Subject: Revision to the Applications for Nationwide Permits 12, 23, & 33, & CAMA Major Development Permit Request for the Replacement of Bridge No. 9 over Bear Branch on NC 130 in Brunswick County; TIP Project B-4030; Federal Aid Project No. BRSTP-130(3); State Project No.8.1231801.

The purpose of this letter is to revise the referenced application with new drawings and answer questions posed by the US Army Corps of Engineers (USACE) and DWQ.

Subject: Replacement of Bridge No. 9 over Bear Branch on NC 130, Brunswick County
TIP Project B-4030, State Project No. 8.1231801
DWQ Project No. 090072

PROJECT REFERENCE NO. B-4030	SHEET NO. 2B
RW SHEET NO.	
ROADWAY DESIGN ENGINEER SEAL 24277 ENGINEER JANNE K. RICHER	HYDRAULICS ENGINEER SEAL 9334 ENGINEER HENRY WELLS

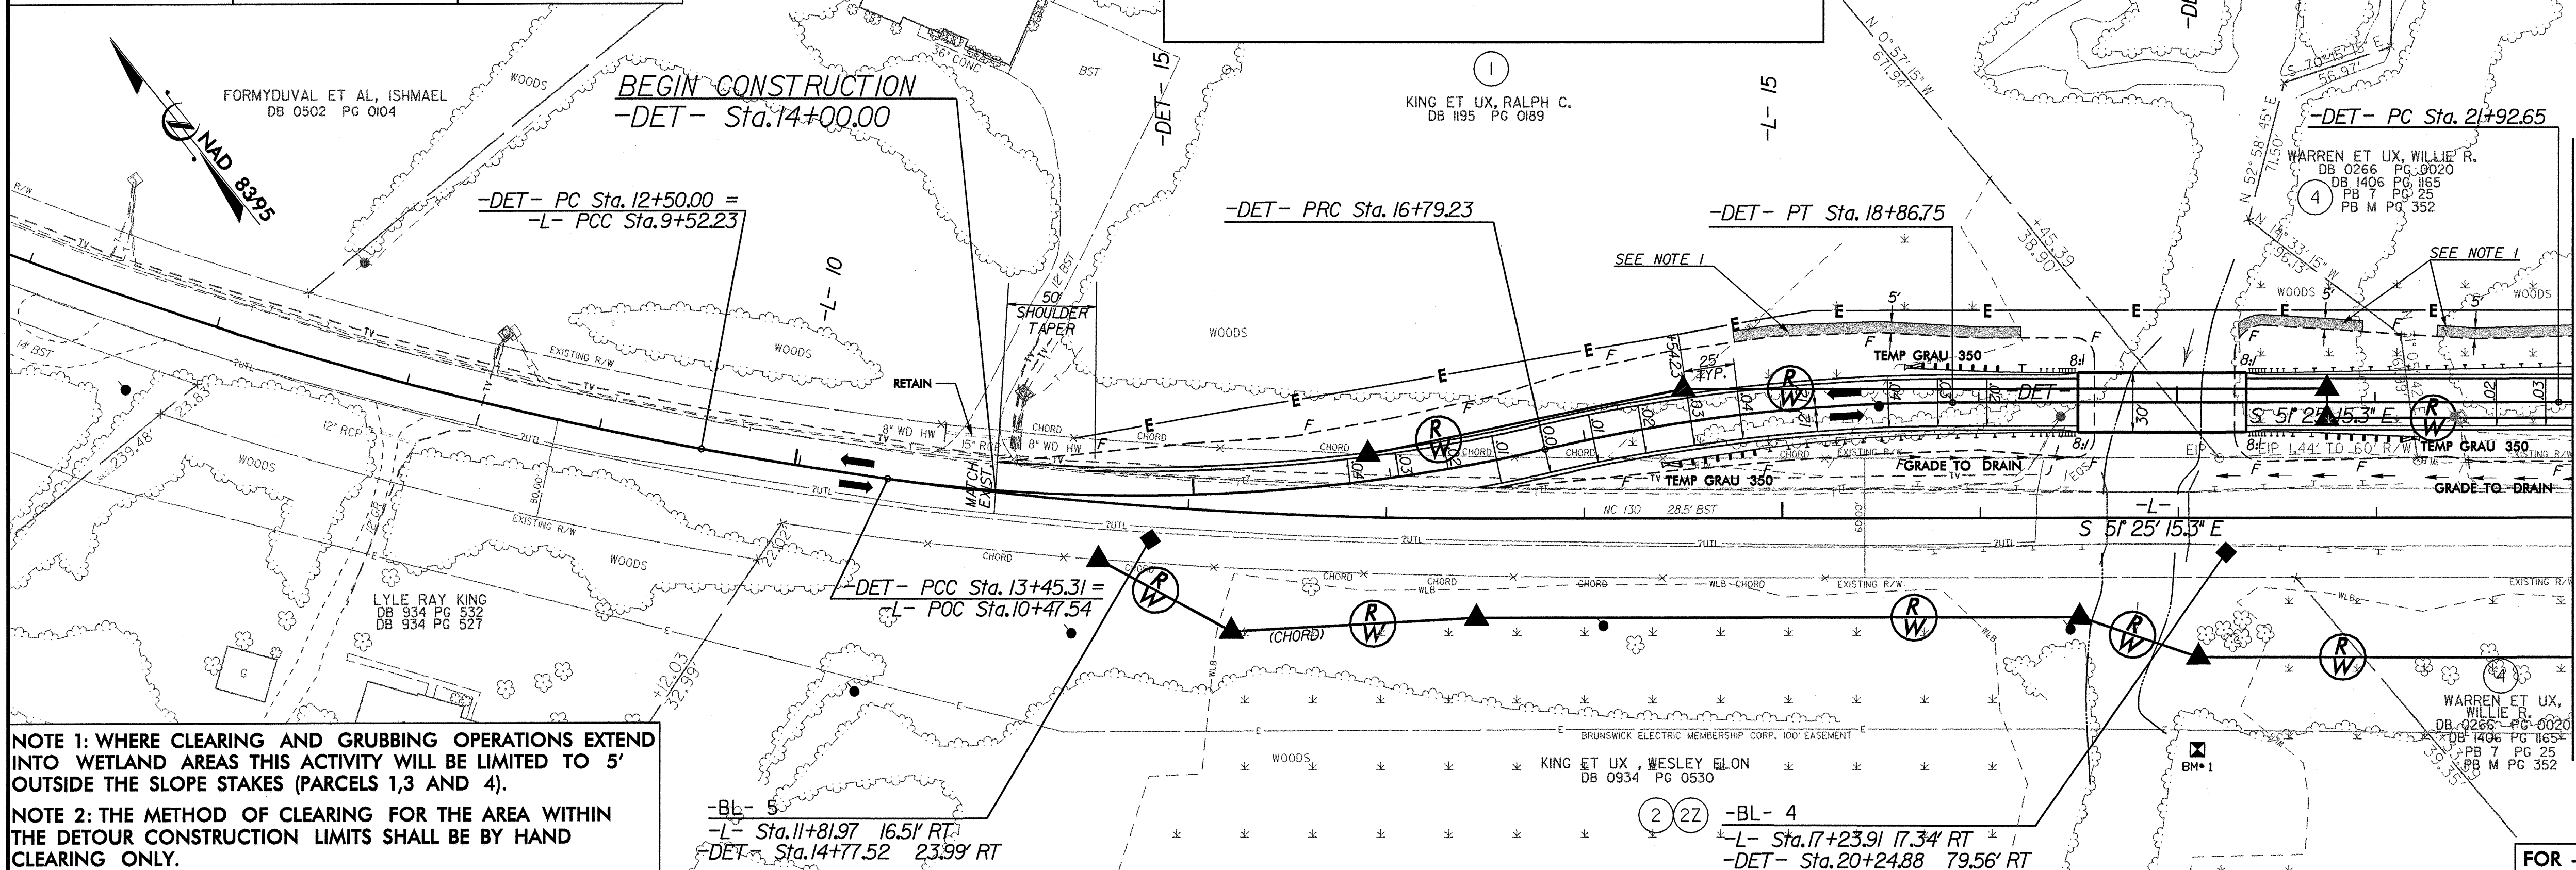
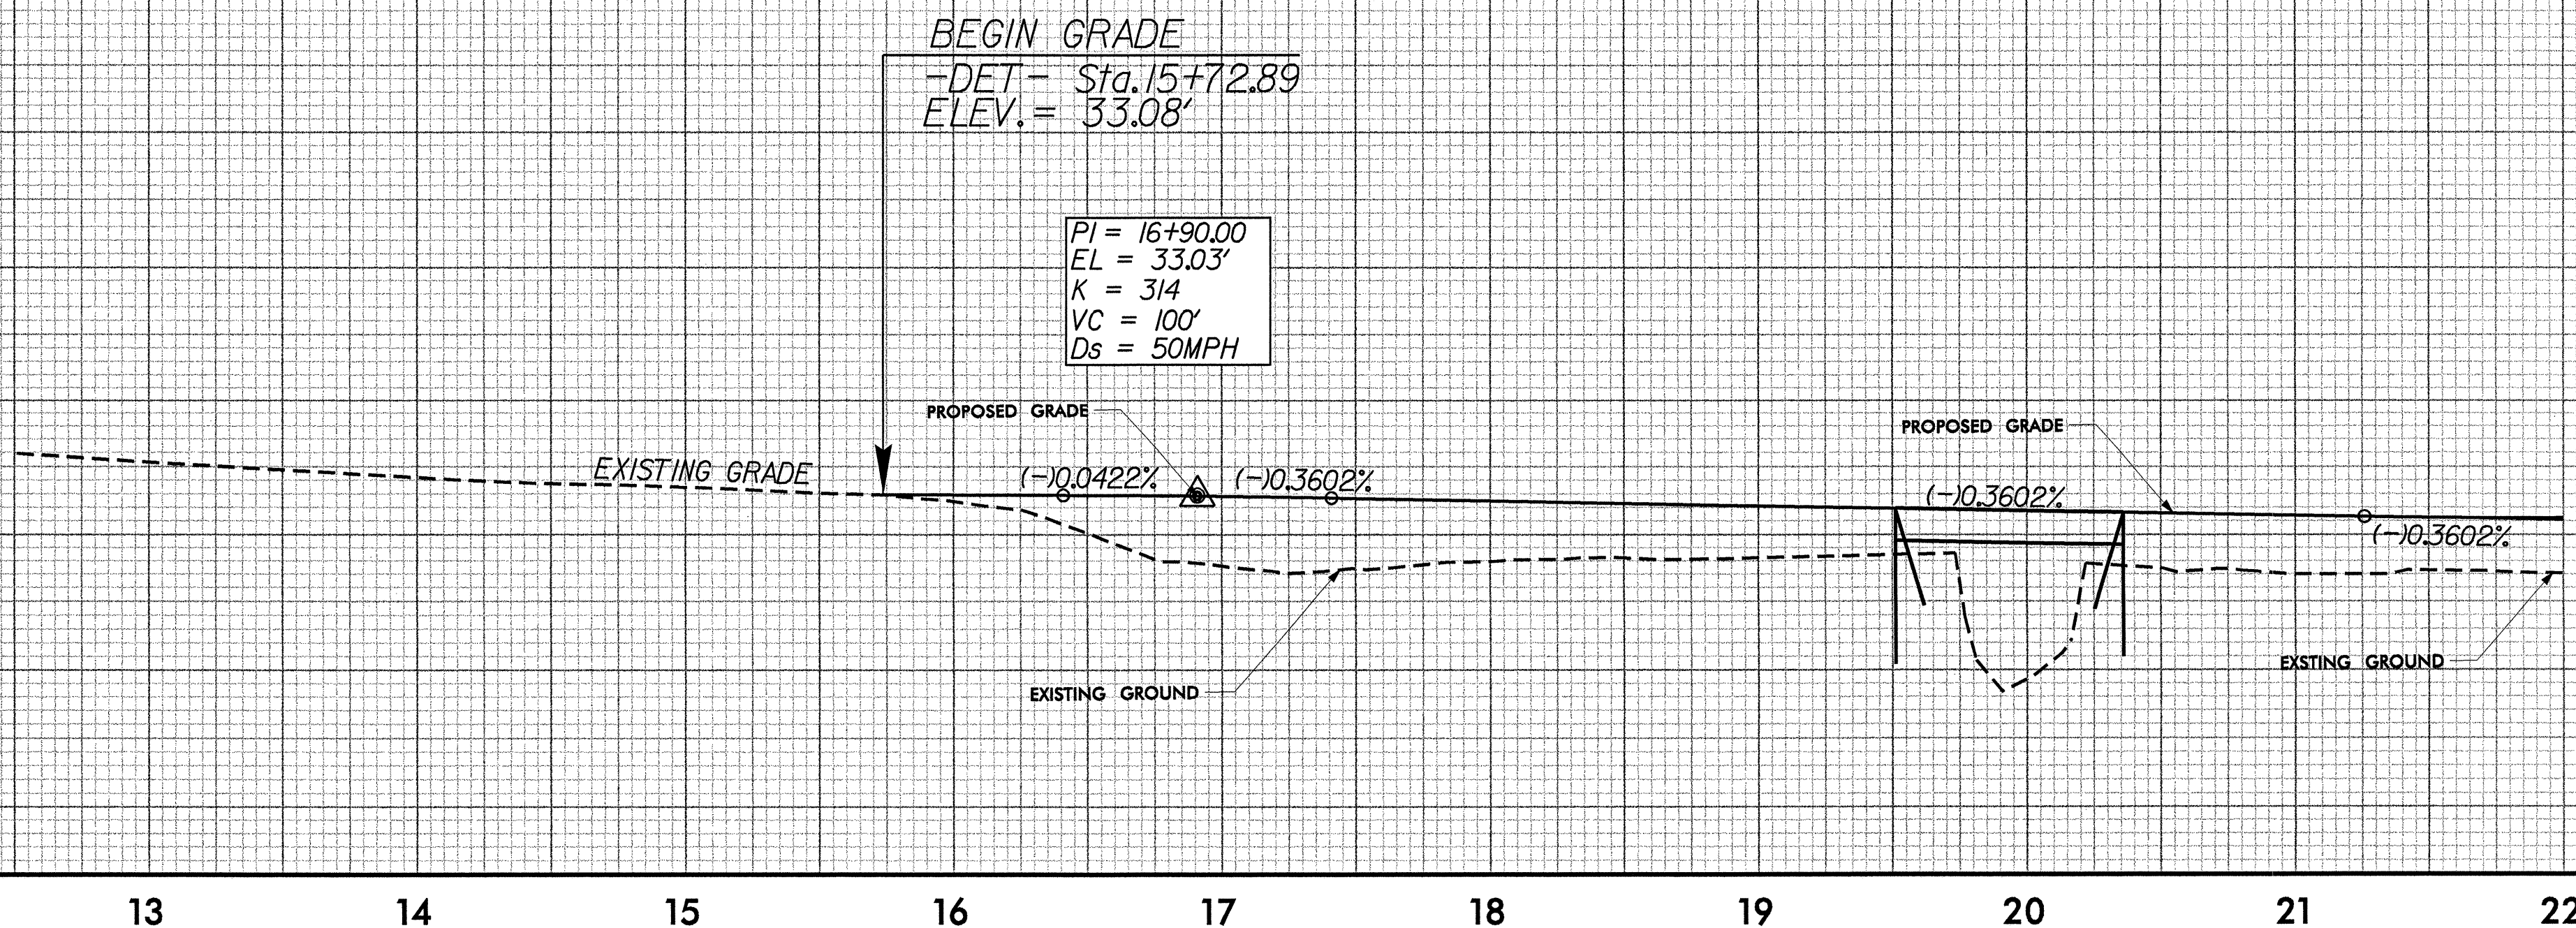
4. Please explain the need for mechanized clearing of the 5 ft. strip beyond the toe of the temporary fill area. This area, like the area under the temporary fill, should be hand cleared flush with the ground surface, resulting in minimal disturbance to the existing soil.

1. There will be no in-stream work.
2. A temporary bridge will be used for the detour.
3. Geotextile fabric will be used under the temporary fill for the detour.
4. There is no mechanized clearing proposed for under the temporary fill.
5. Approximately 100 feet² is the area of the riprap at the outlet end of the grassed swale.
